# CITY OF ALBUQUERQUE

**Re: L&C Transport Private Metal Garage, 8705 Central Ave NW,  
Traffic Circulation Layout, Engineer's Stamp dated 04-12-13 (K9-D037)**

Based upon the information provided in your submittal received 4-22-13, the above referenced plan cannot be approved for Building Permit until the following comments are addressed:

TRAFFIC CIRCULATION LAYOUT

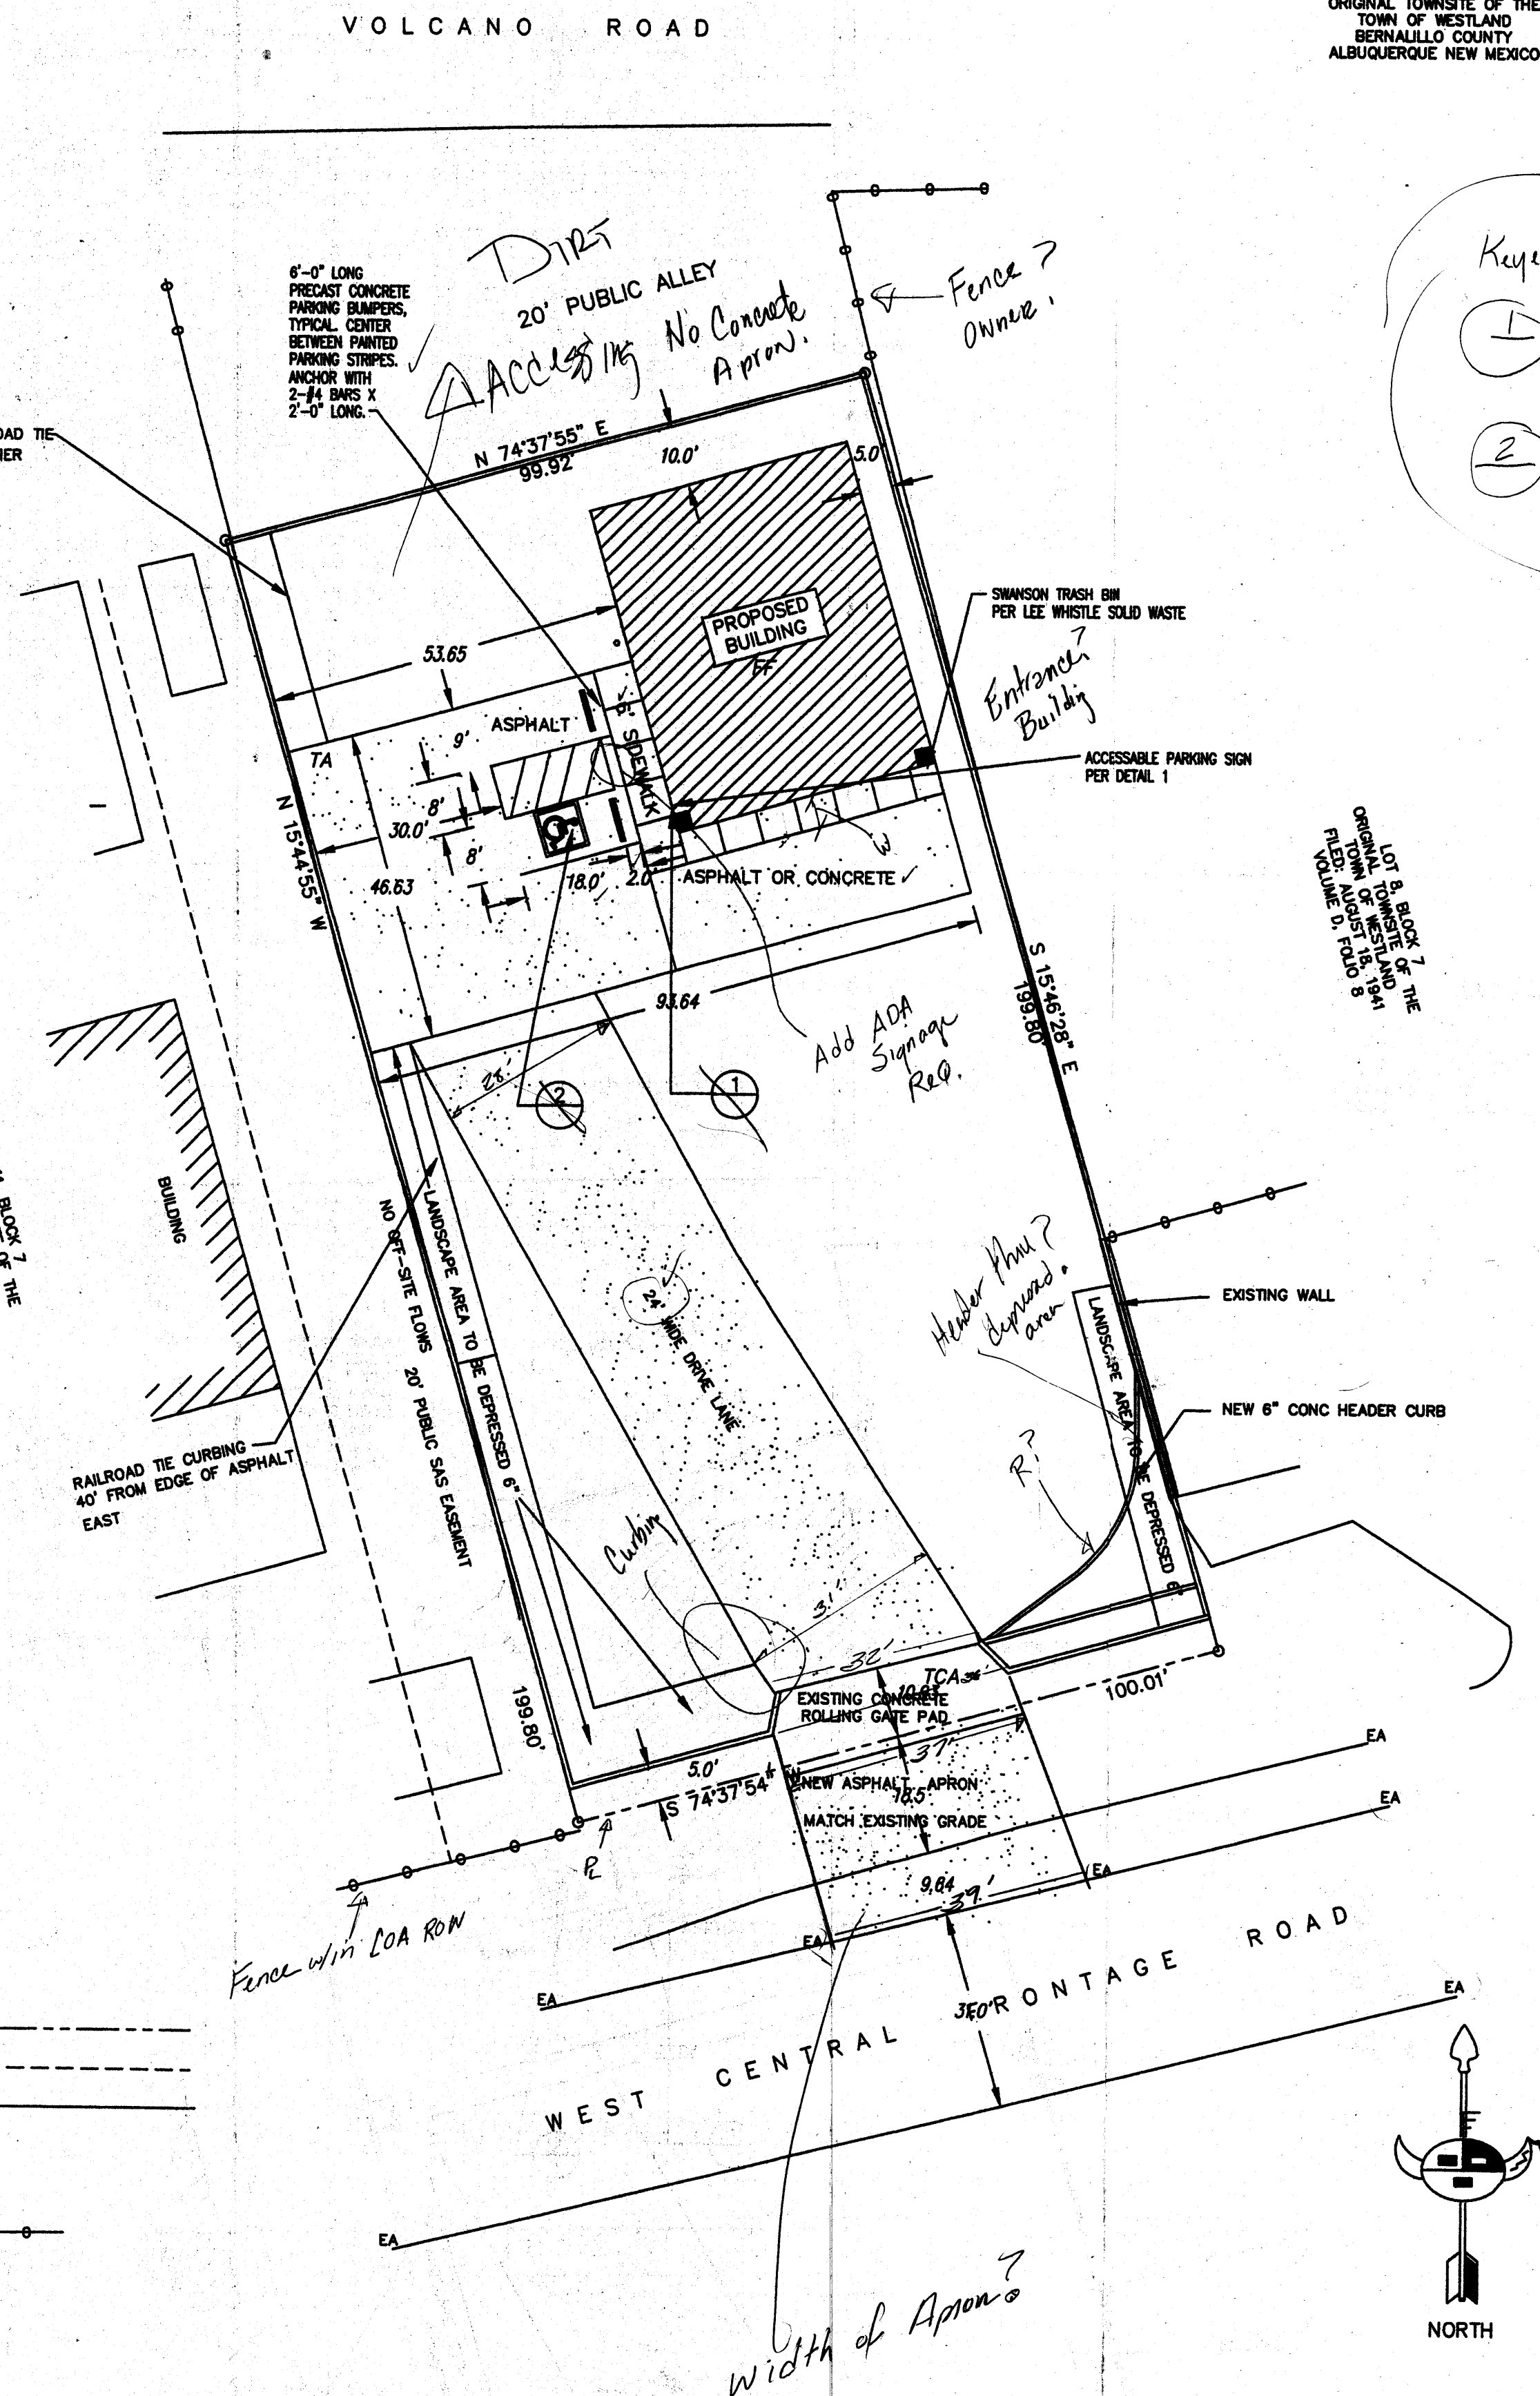
3. Please define, dimension, and label all proposed infrastructure to be built on private and public property (including posted sign at handicap stall, width of new asphalt apron abutting Central, proposed sidewalk adjacent to south side of building, the entrance to building).

4. Please provide the width of "existing concrete rolling gate pad." Does this concrete pad meet DPM standards?
5. Please remove all unused notes from TCL site plan or clarify (keyed notes 1 & 2).

6. TCL shows a segment of "depressed" landscape area adjacent to west side of proposed Drive Lane. Header curb is required where landscaping and drive aisles abut.

7. Please clarify why "new 6 inch header curb" is drawn into the depressed landscape area on eastern boundary.
8. The development of this site must be in compliance with current DPM and ADA standards and regulations.

9. Will this site access the alley abutting north boundary onto Volcano Rd.?
10. Will this site be fenced? Will there be access gate(s)? Please clarify and provide necessary details.
